**Consultation Response from KC,
Lead Local Flood Authority**

2020/90119 Former Petrol Station, North Road, Kirkburton, Huddersfield, HD8 0RL

Discharge conditions 12-16 on previous permission 2016/93935 for demolition of existing petrol station and erection of 4 retail and residential units (within a Conservation Area) (modified proposal)

**Date Responded:
24 November 2020**

Title: DRAINAGE LAYOUT			
Job No: 2242	DRN: MM	Date: 24/12/2019	
Scale: 1:125 (A1)	CHK: UD	DRG. No.: ESE-DR-S-001: P1

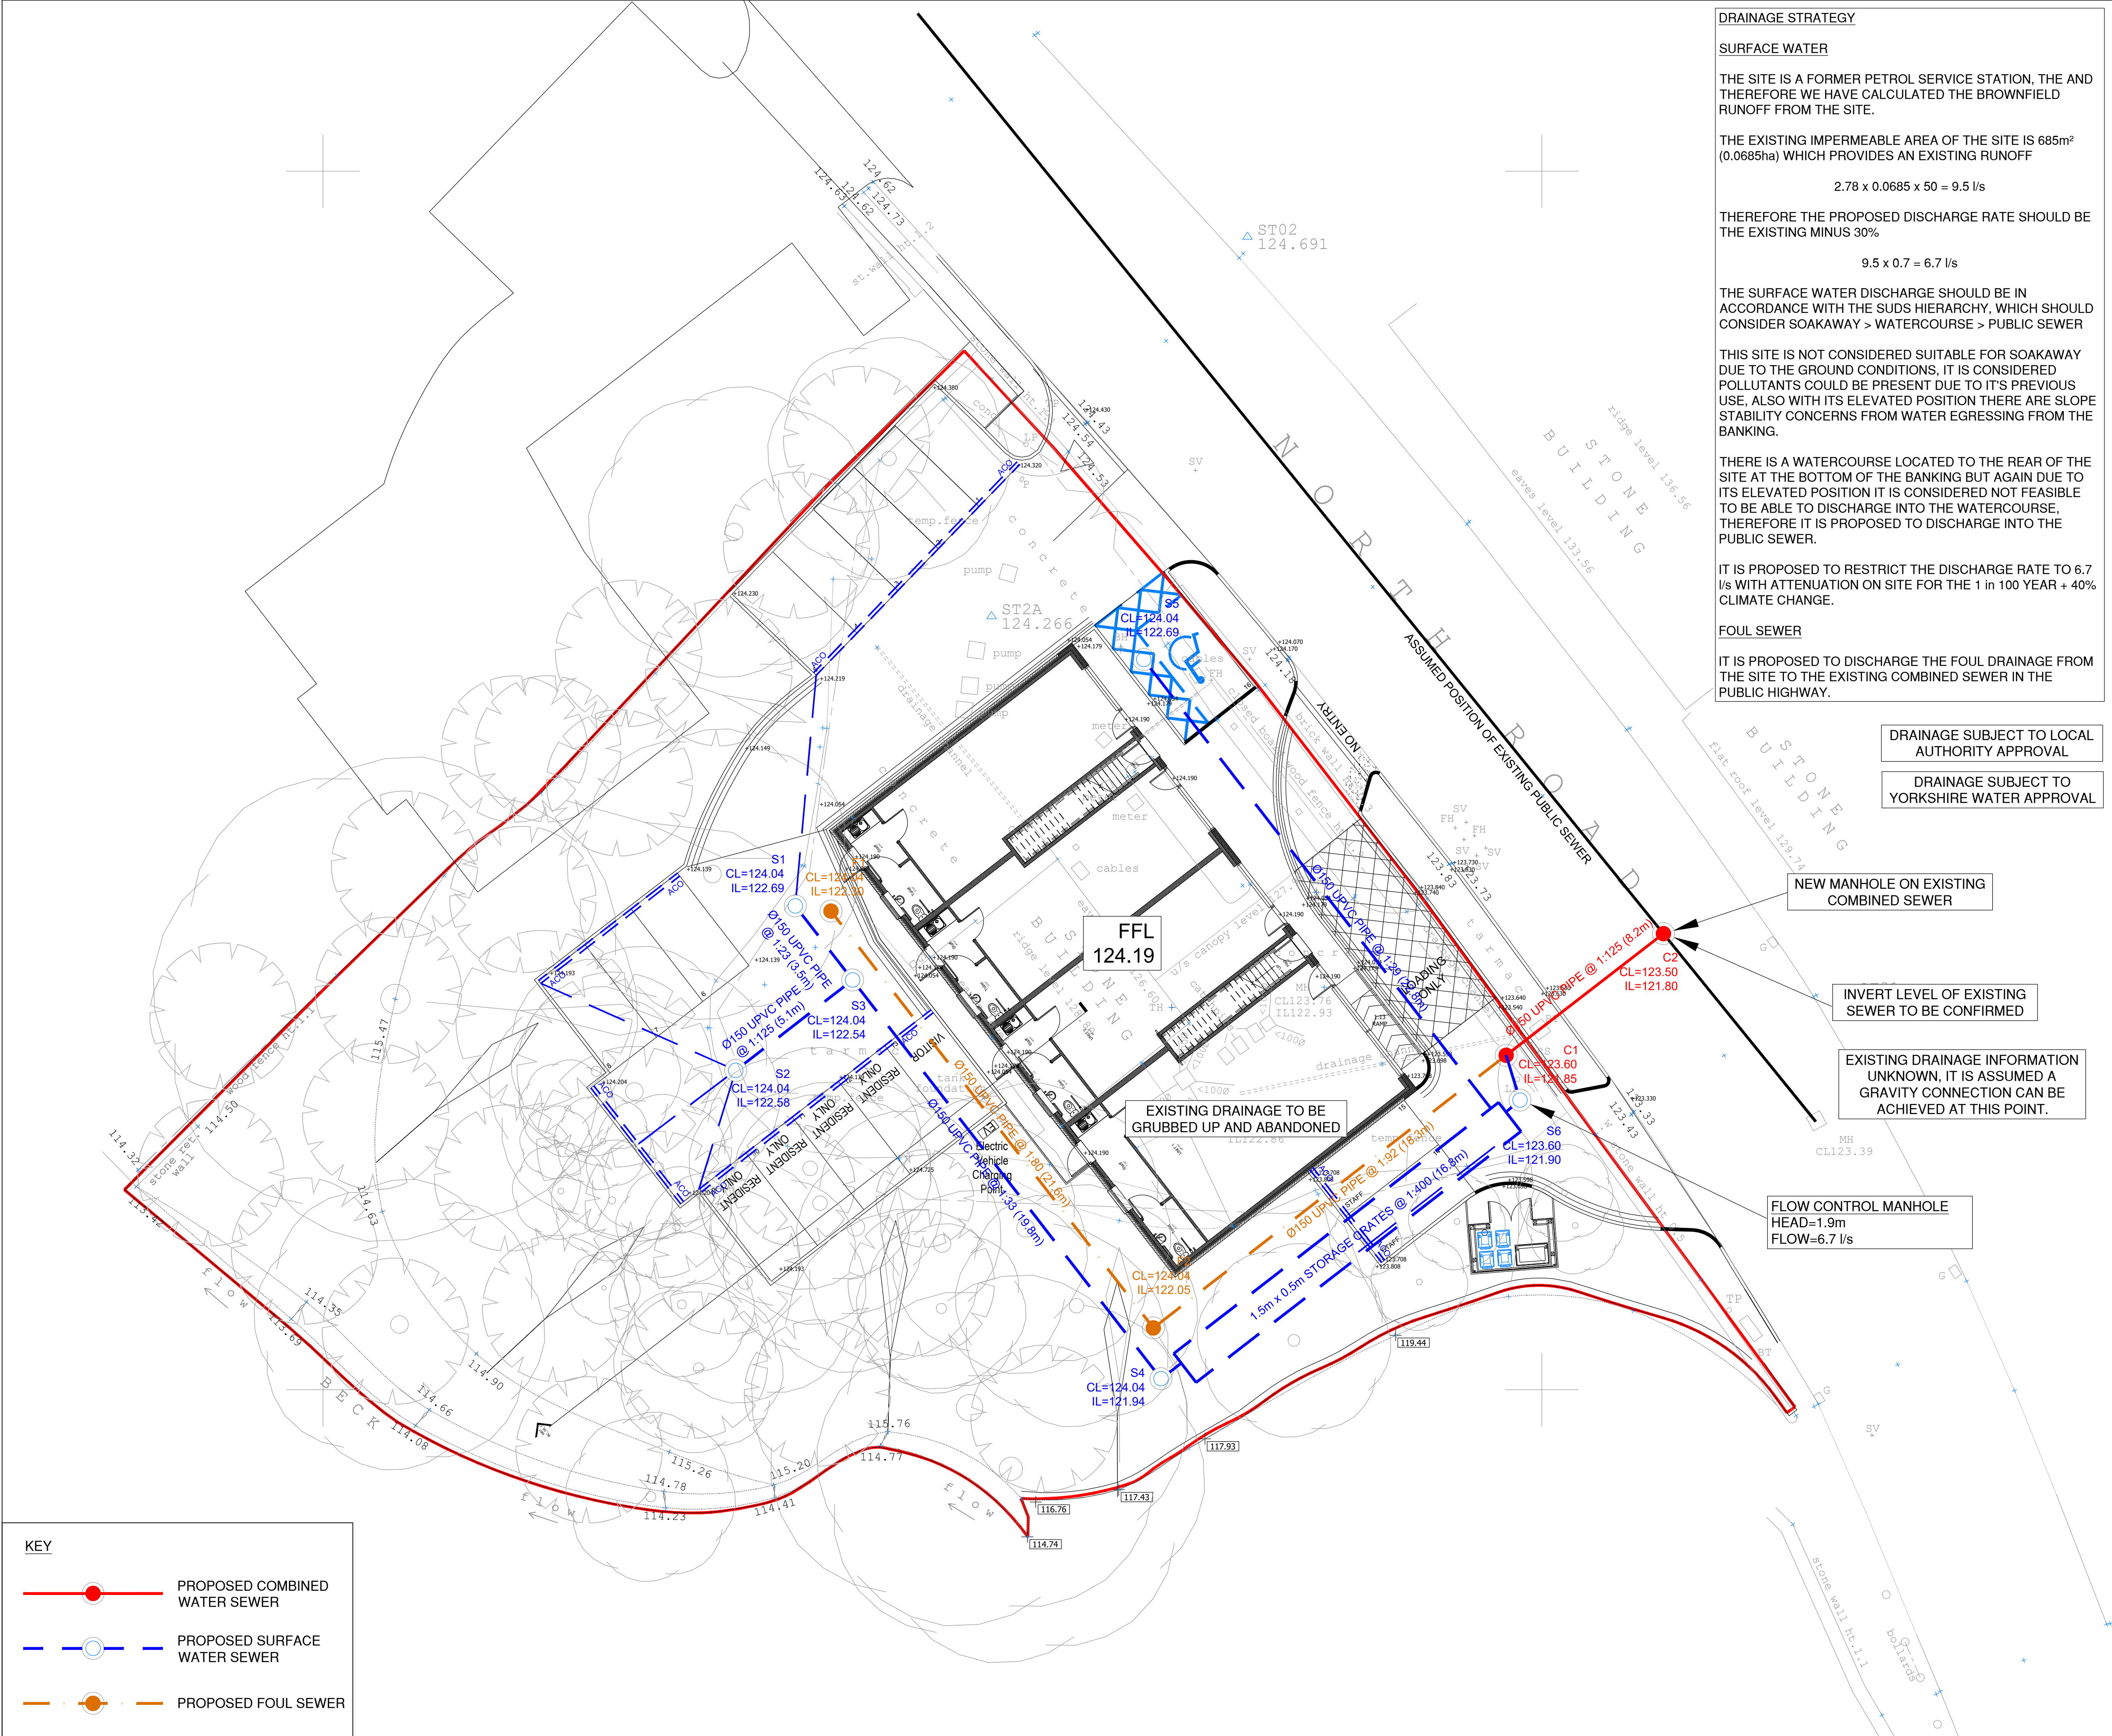
- Kirklees LLFA have previously stated that all pipe joints require manhole chambers. Locations where channel drains connect to the pipe network still do not have any manhole chambers. Commonly, ACO sump chambers with grate lids are used for this function rather than a standard manhole chamber. The applicant should review and revise plans accordingly.
- As stated in the previous response, it appears that the updated documents show inconsistencies in CL for manhole C1 – the drawing shows this as 123.60mAOD, while the MicroDrainage shows it as 124.300mAOD. This should be amended and updated documents submitted for review.

- There is no information on the required attenuation sizing – calculations should be provided to show that the proposed storage crates are sufficient.
